RIBBLE VALLEY BOROUGH COUNCIL

RE: REQUEST FOR PRE-APPLICATION ADVICE
THORNBER'S, SLAIDBURN ROAD, WADDINGTON

Thank you for your enquiry concerning alterations and extension to the Grade II listed house within the Forest of Bowland Area of Outstanding Natural Beauty. The submission includes a very informative heritage assessment which identifies evidence for the building's origins as a cruck frame structure.

Proposed Floor Plans
 DATE 14.03.18

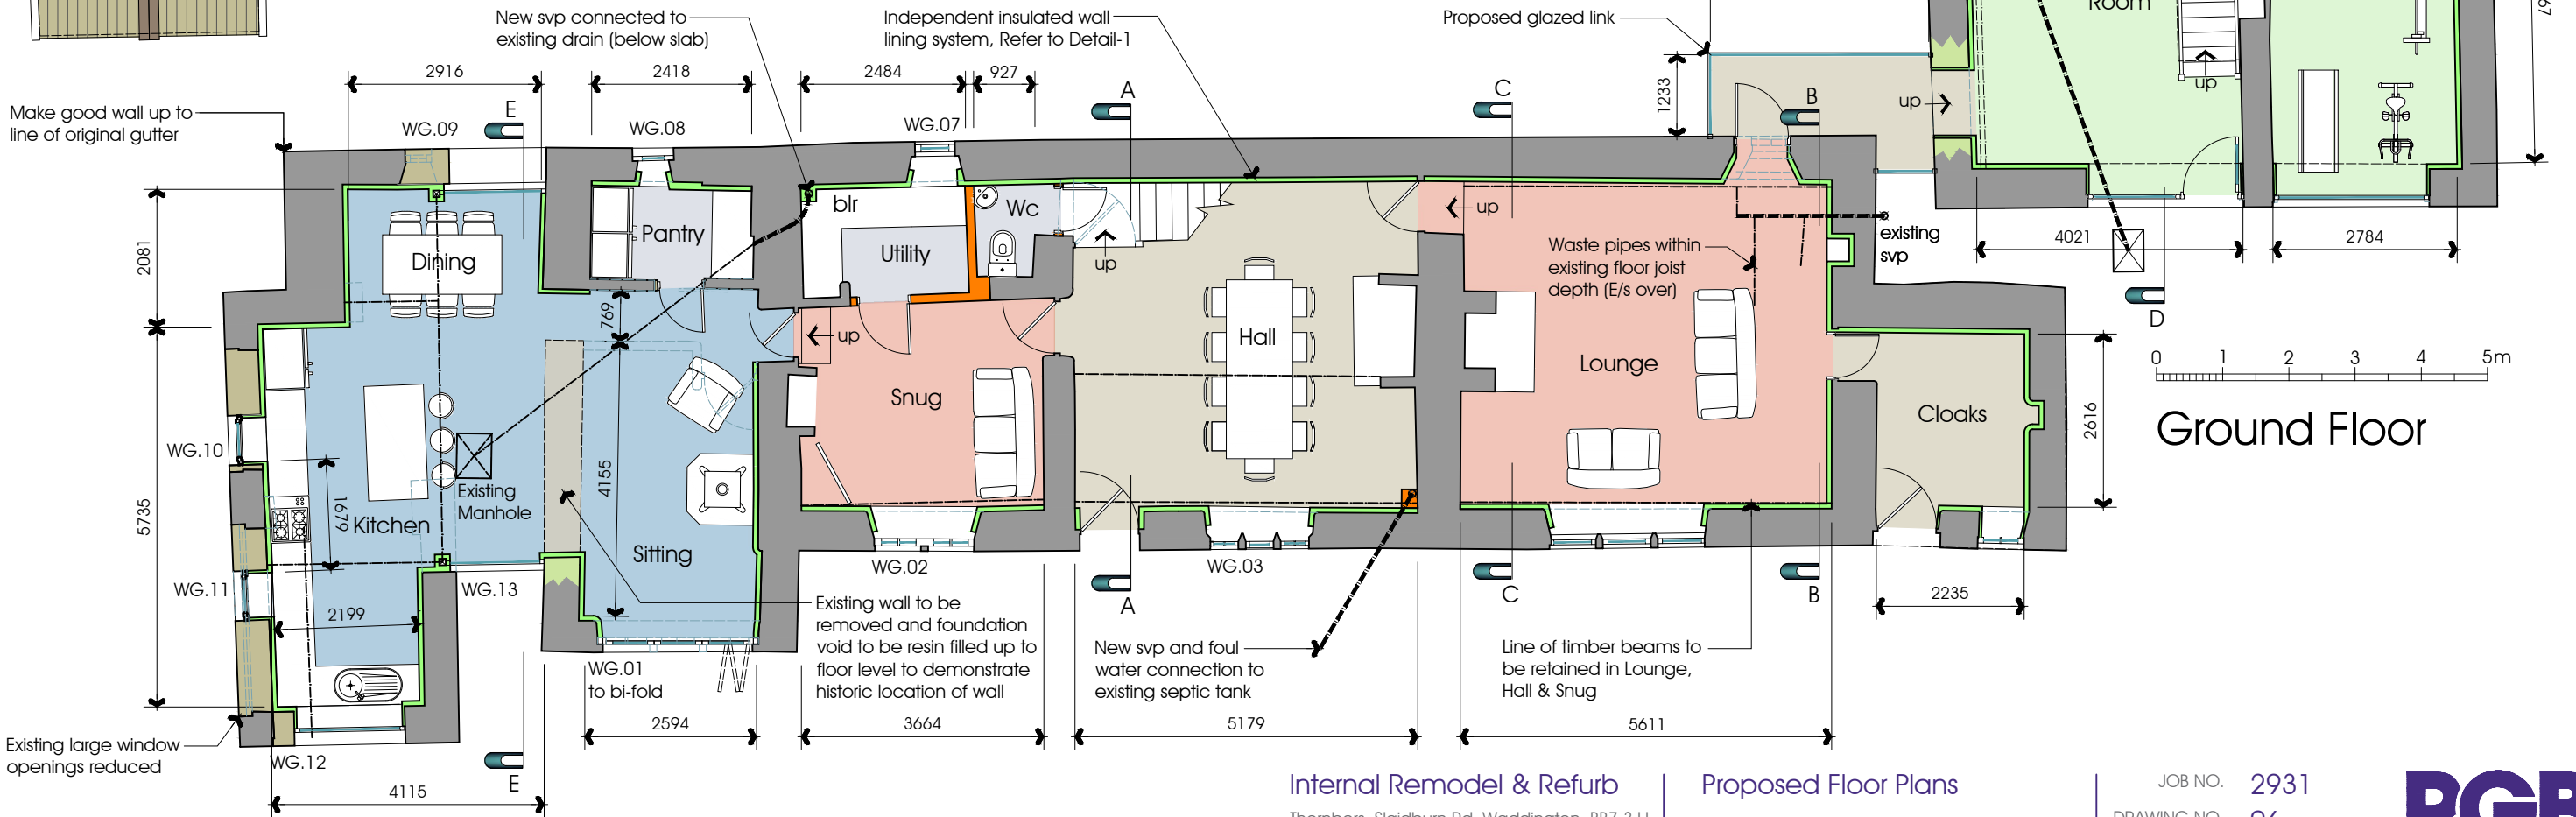
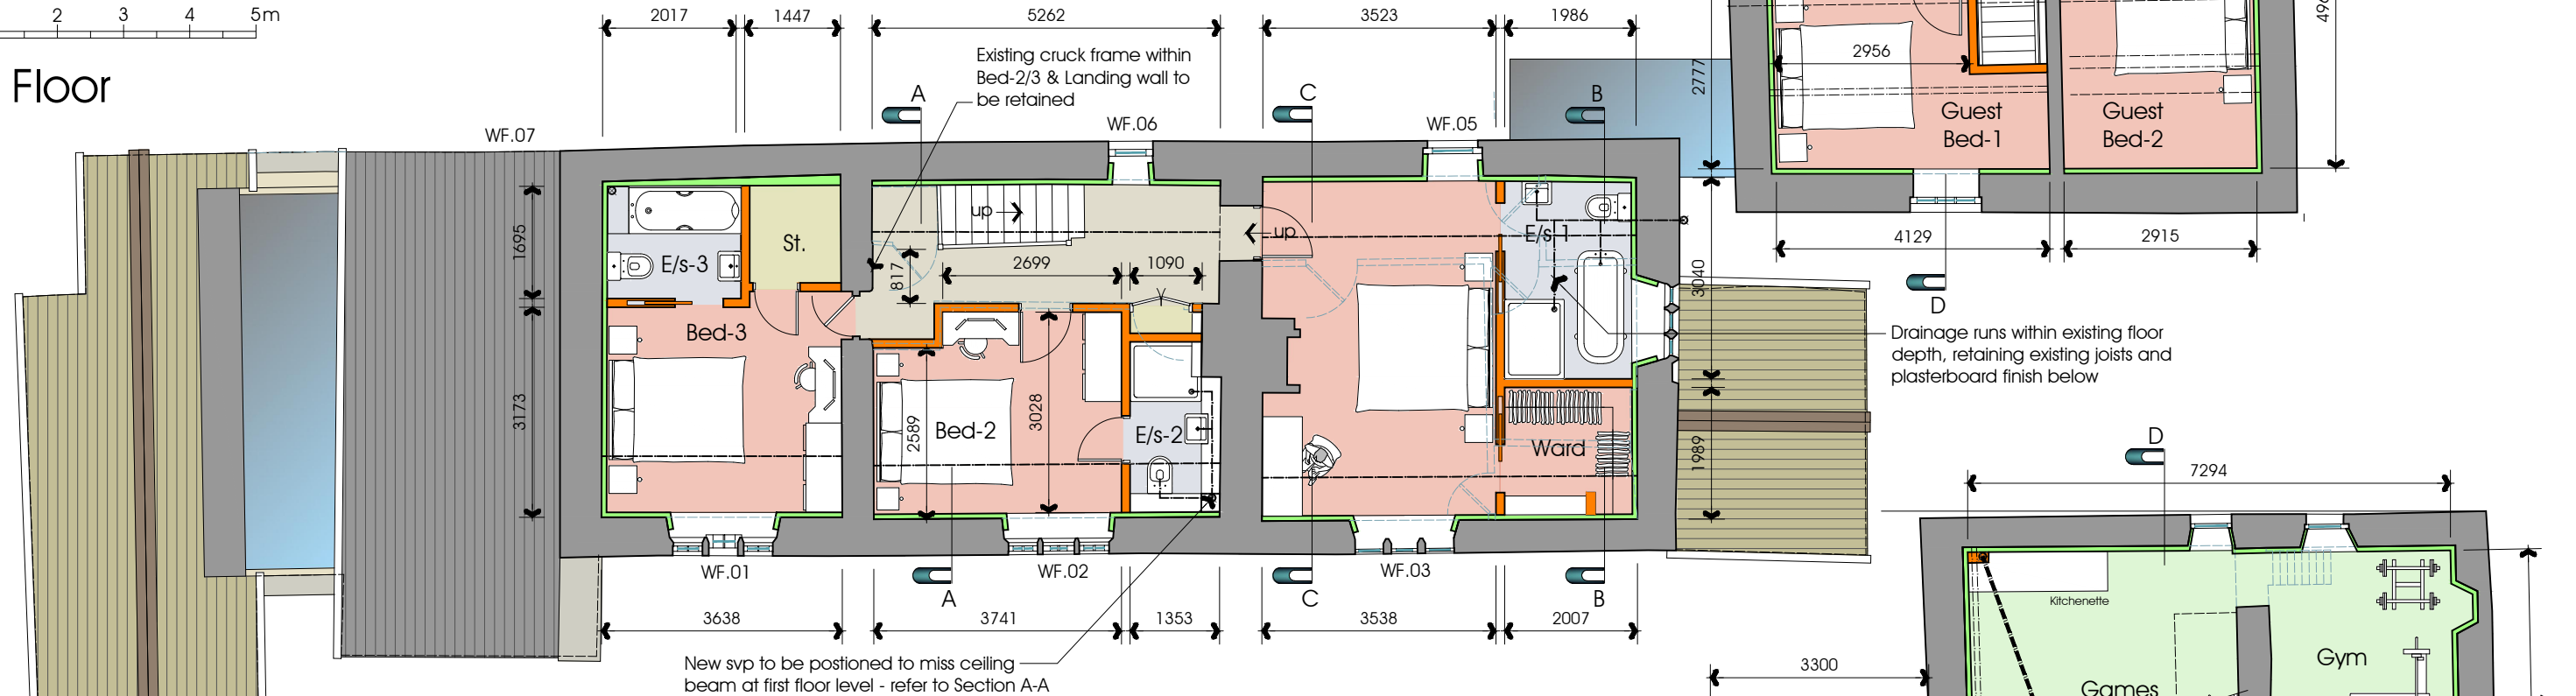
I write to confirm comments made at our site meeting of the 11 August 2017. I understand the proposed planform changes have been informed by consideration to modern alterations identified within the planning record. In this respect, the proposed planform changes at first floor appear relatively minor and acceptable in general. However, the cruck frame is to be further concealed within an en suite to bedroom 2 – is this essential? I would suggest that full details of en suite provision to all bedrooms (including impact on and protection of historic fabric) be provided at application stage.

South (front) elevation 0 1 2 3 4 5m

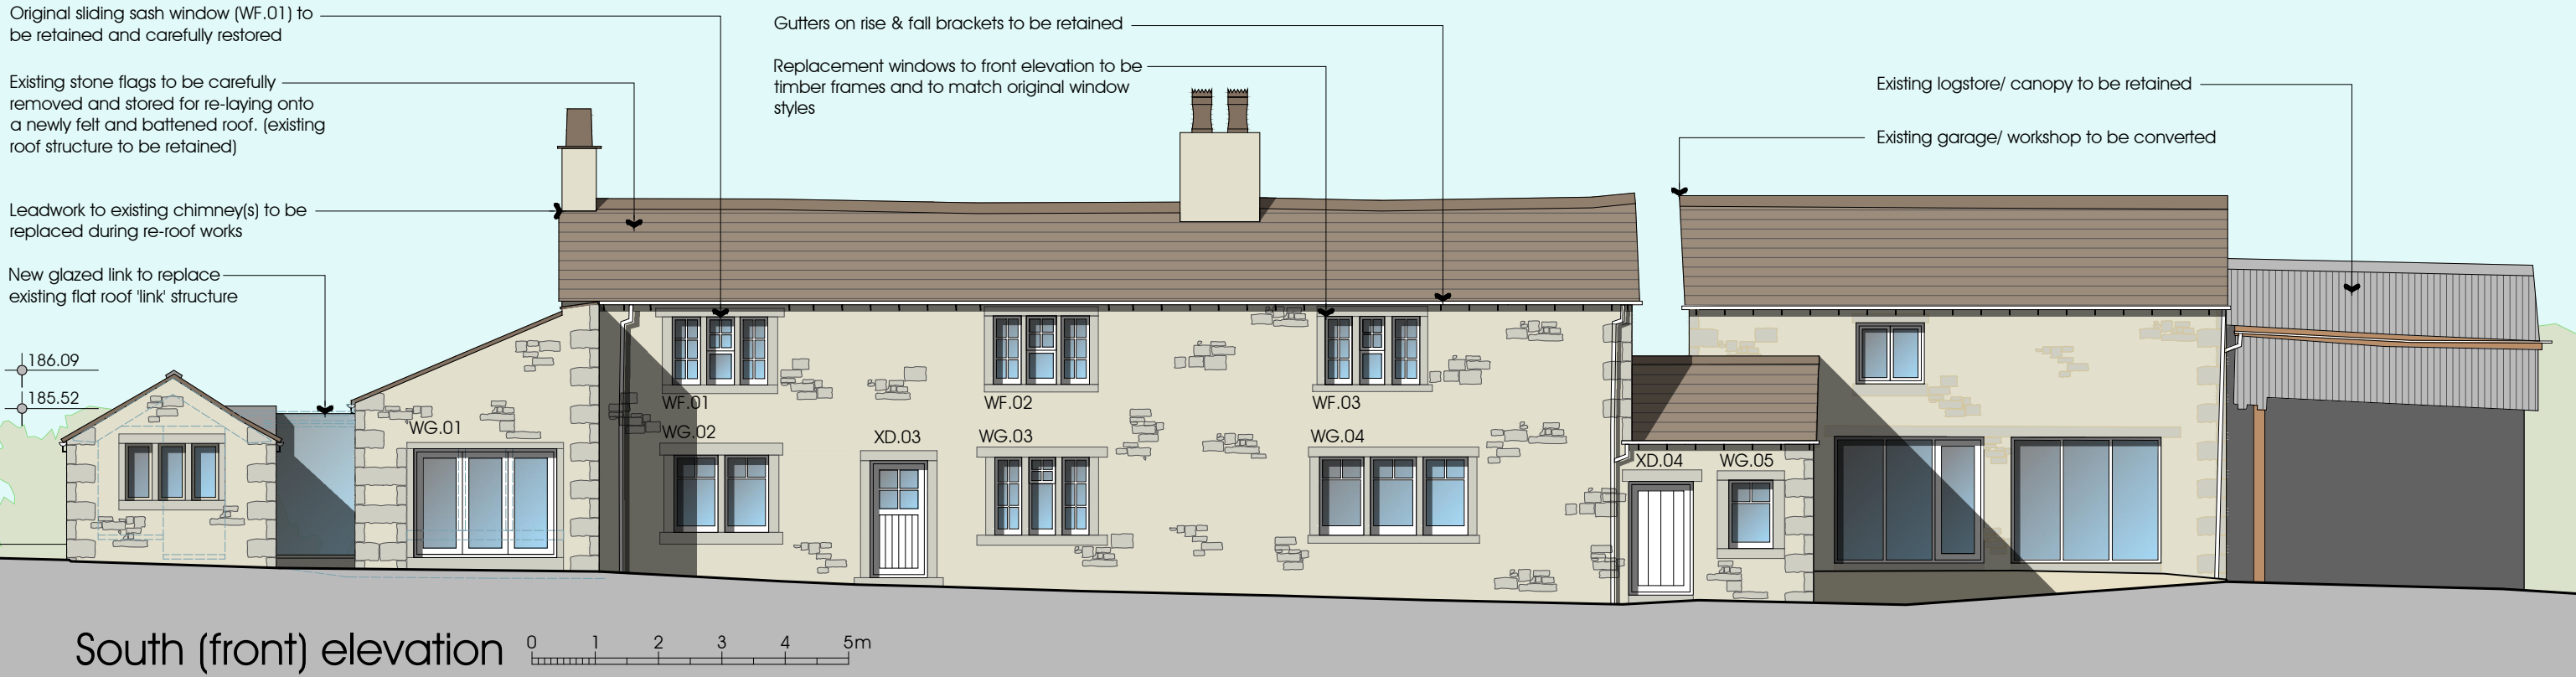
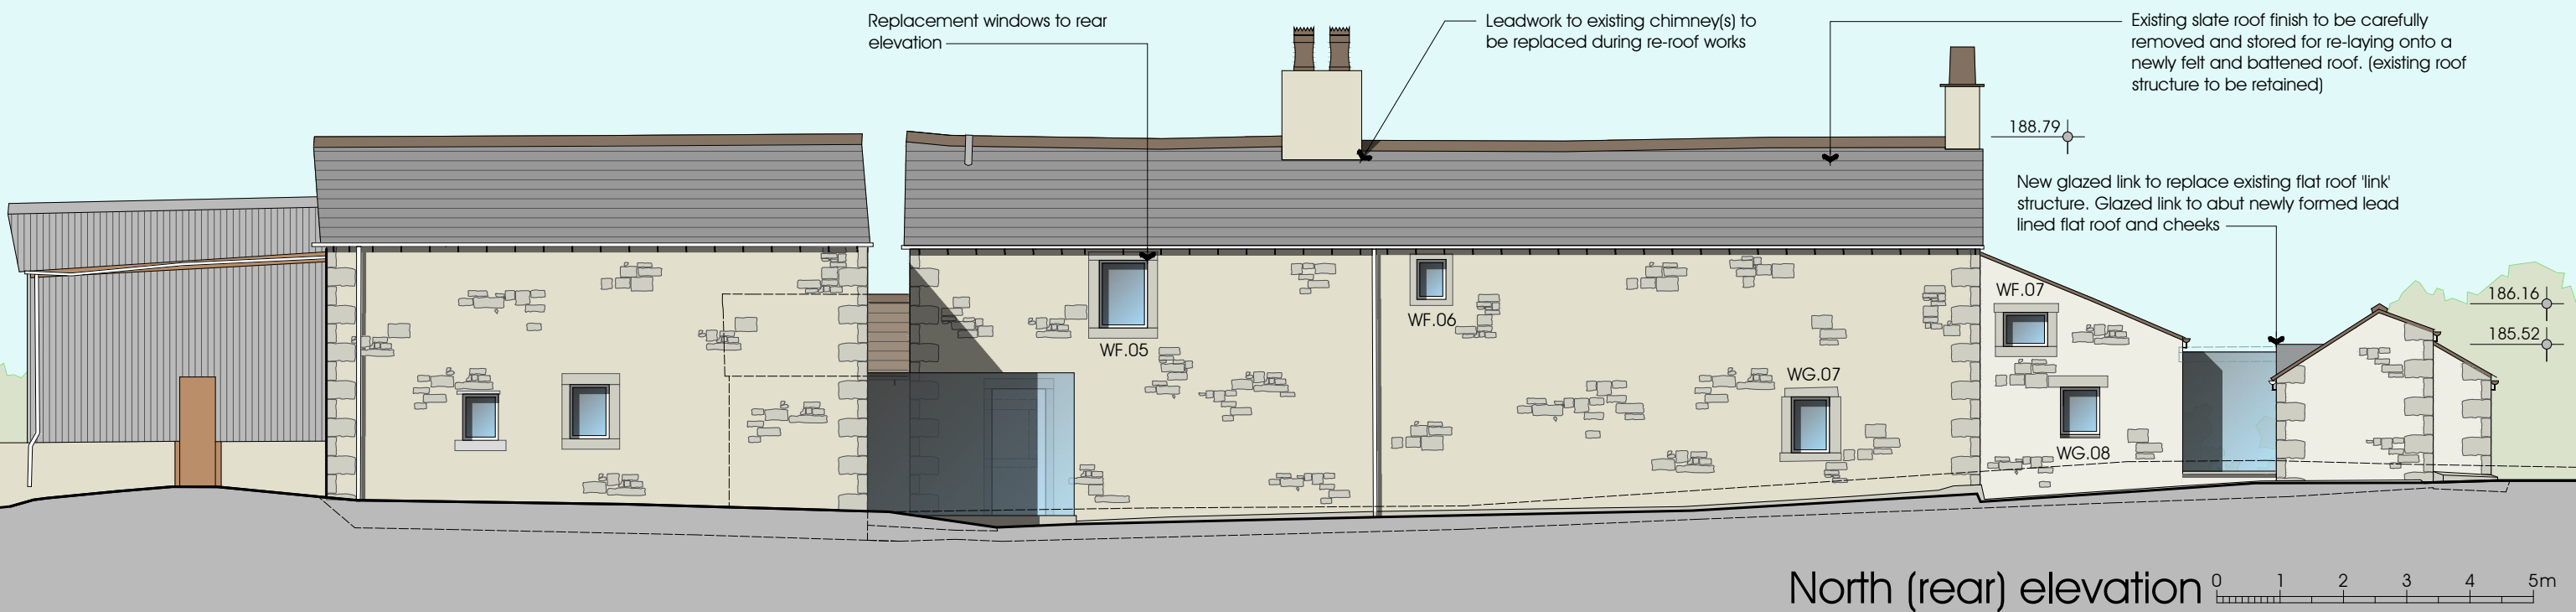
The principal of enhancement to fenestration is welcomed. Historic England's "Traditional Windows: their Care, Repair and Upgrading" (February 2017) provides advice in this regard. One example of similar tri-partite windows in the borough is Hill Foot Cottages, Twiston. The list description states: "row of 3 houses, late 18th century ... windows tri-partite, stepped, with plain stone surrounds and square mullions ... the inner light of each window is sashed with glazing bars and the outer lights fixed with glazing bars".
